# Urban Design Review Panel Report - Revision 1

## 500 Coventry Road, Ottawa

**RE: Urban Design Review Panel Report – Revision 1  
Site Plan Control Application  
500 Coventry Road, Ottawa**

Enclosed, please find responses to the Urban Design Review Panel's comments provided on February 2, 2024, regarding the Site Plan Control application for the property municipally known as 500 Coventry Road, Ottawa.

DRAWING NO: SPA005B
REV: 5

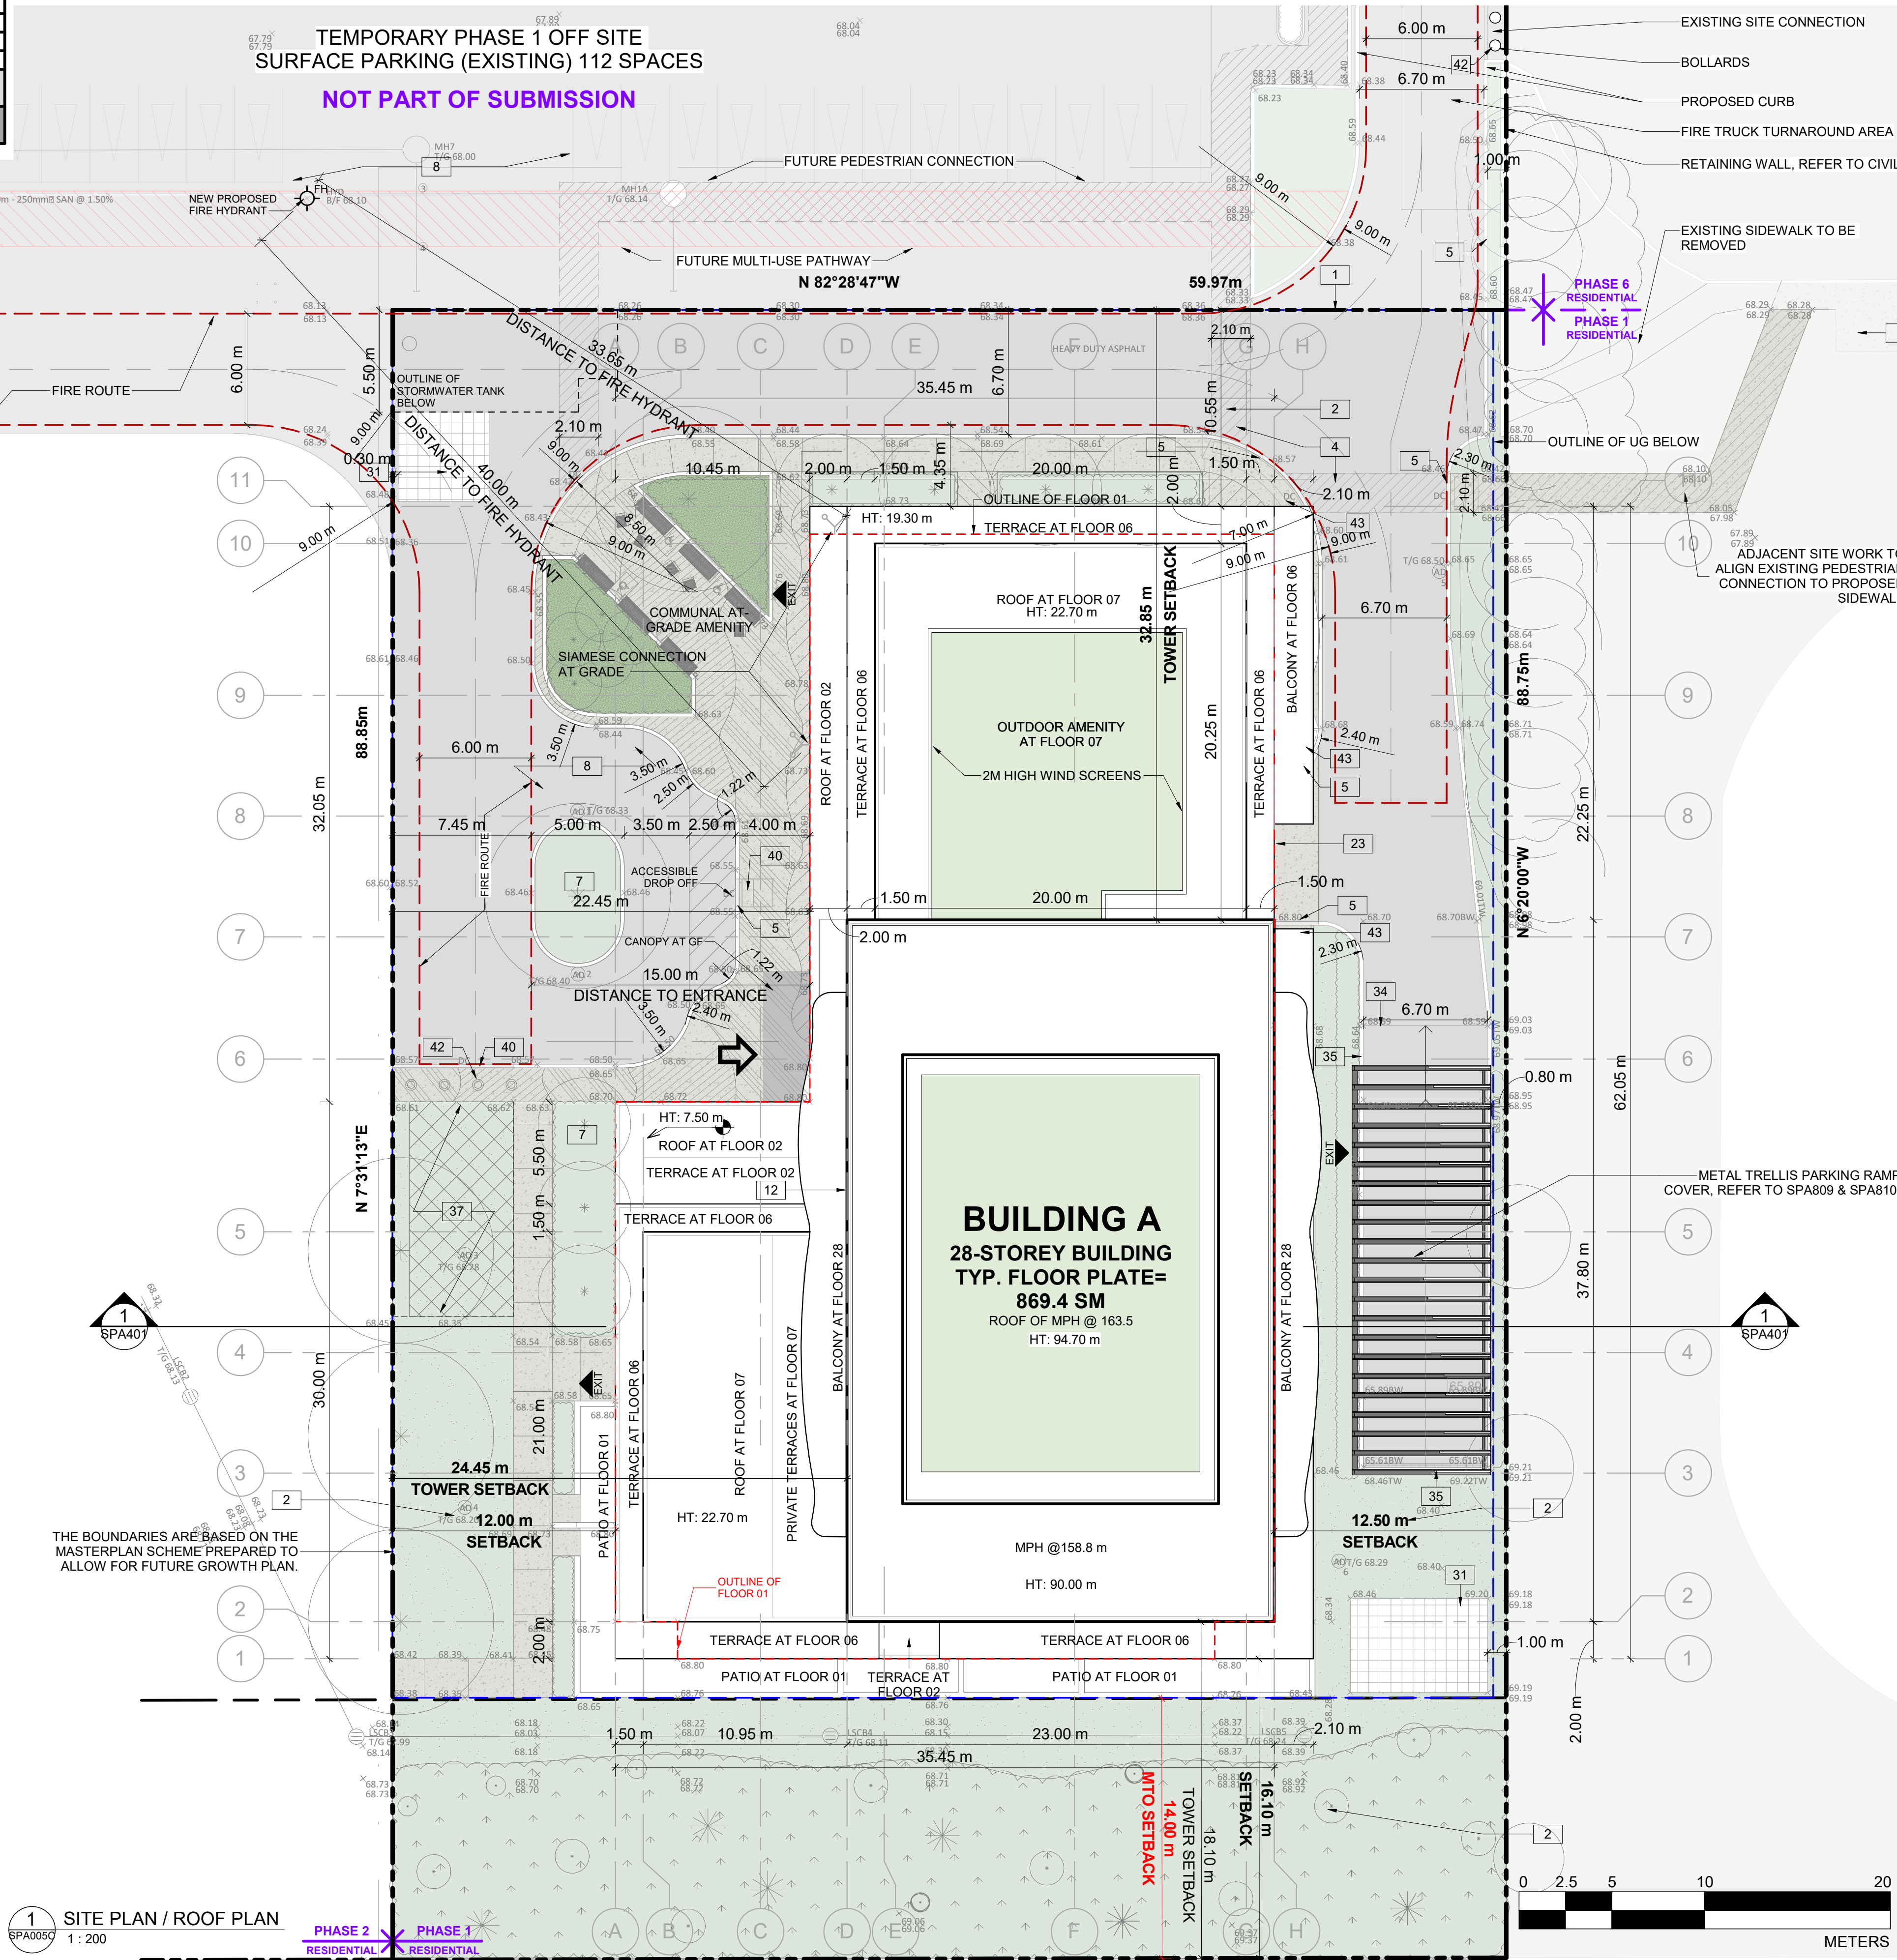
24. The Panel recommends further exploring ways to mitigate a sense of isolation for the first building in the interim.

- Consider how best to integrate the building with its surroundings prior to the rest of the build out of the site.

**Response:** The site plan has been developed to include pedestrian connection from public and to adjacent site. Landscape and grade have been coordinated to tie in with existing condition, providing smooth flow for pedestrians, cyclist and vehicle. Refer to SPA005B, C.
